Reference: CR:KG LTR/C 19005C

24th February 2020

RE: TWEED VALLEY HOSPITAL – RESPONSE TO SUBMISSIONS FOR STATE SIGNIFICANT DEVELOPMENT

Stage 2 SSD – 10353 EIS Submission:

Drawing Number	Revision
RBG-CV-DWG-RIE-82-722	1

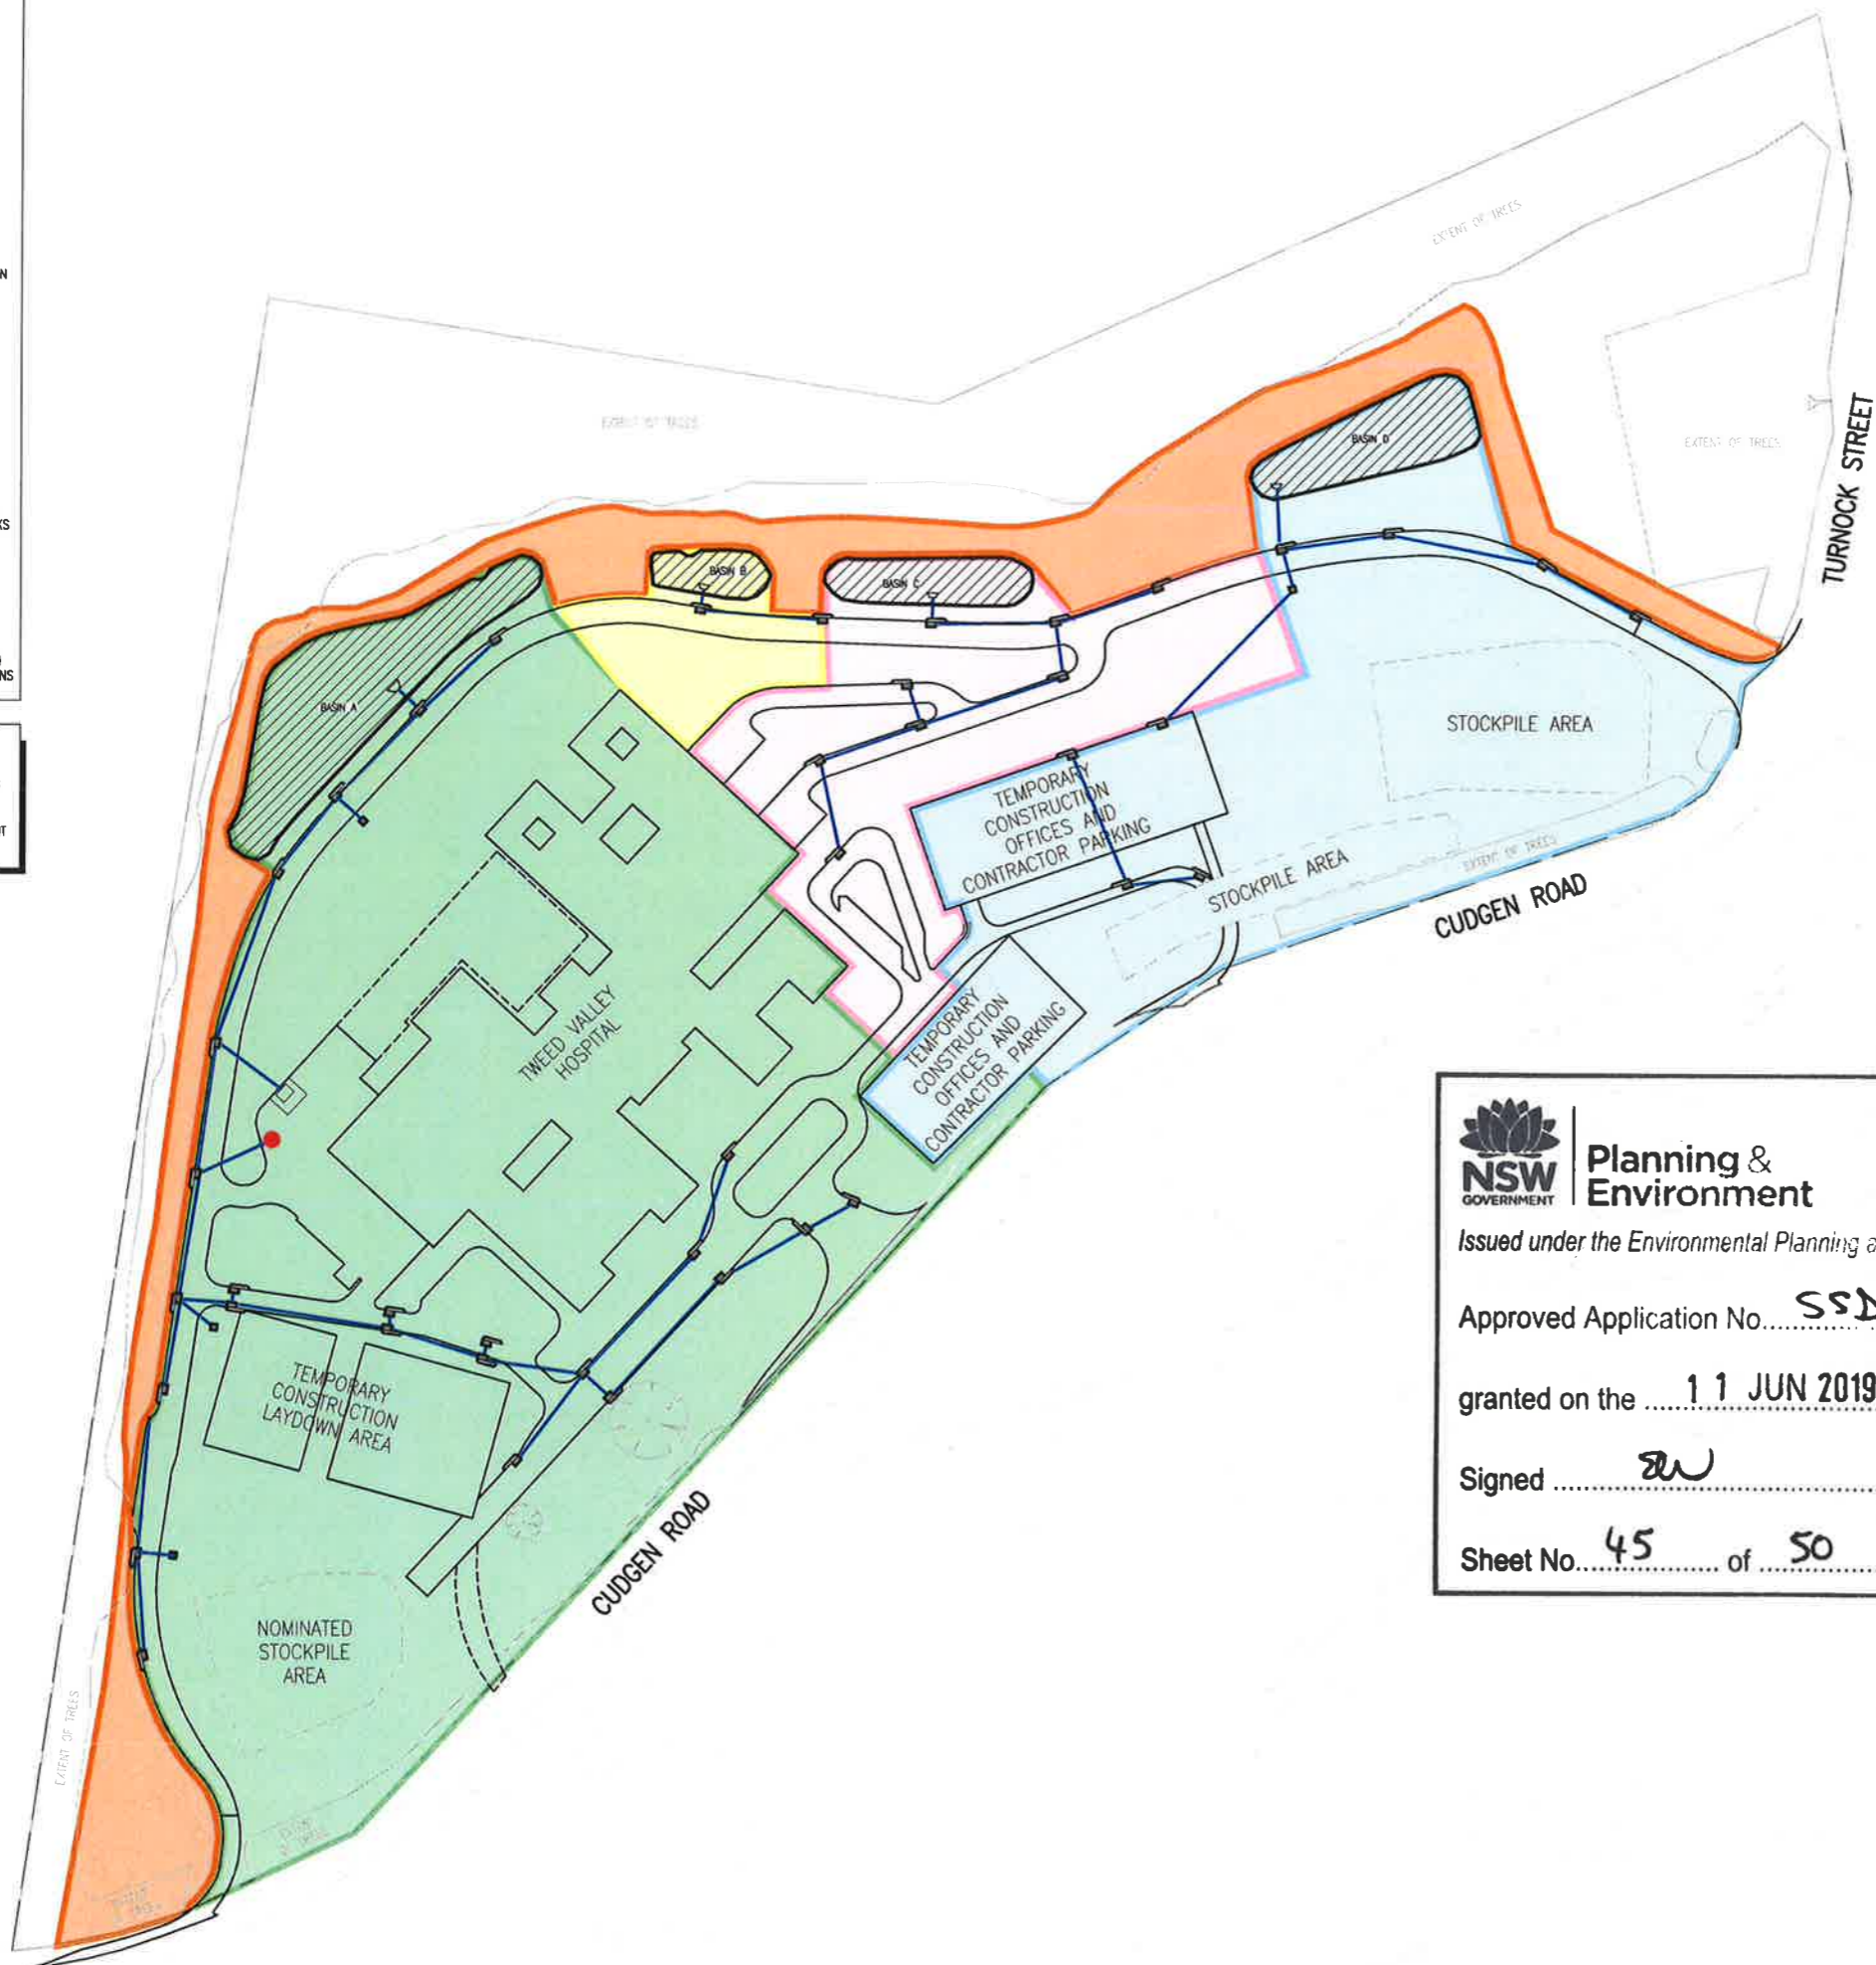
Comment: Greater effort should be given to reducing the stormwater volumes entering the basins, such as including more storage and reuse of runoff and more use of swales and raingardens in suitable locations.

Response: A 400KL rainwater reuse tank will be provided to collect and store rainwater from the hospital roof to use for irrigation and cooling tower. It is estimated by the hydraulic consultant that reusing stormwater for this purpose will reduce the total stormwater discharge by approx. 17ML per year on average. RBG have considered provision of infiltration devices such as swales and raingardens to further reduce the site runoff, however, geotechnical advice has been received which confirms that doing so would increase the risk of slope slip failure on the steep batters around the site due to waterlogged subsoil – refer to Morrison Geotechnic letter (Appendix A). For this reason, infiltration devices cannot be provided and the bio-detention basins will have an impermeable liner as shown in updated drawing RBG-CV-DWG-RIE-86-310.
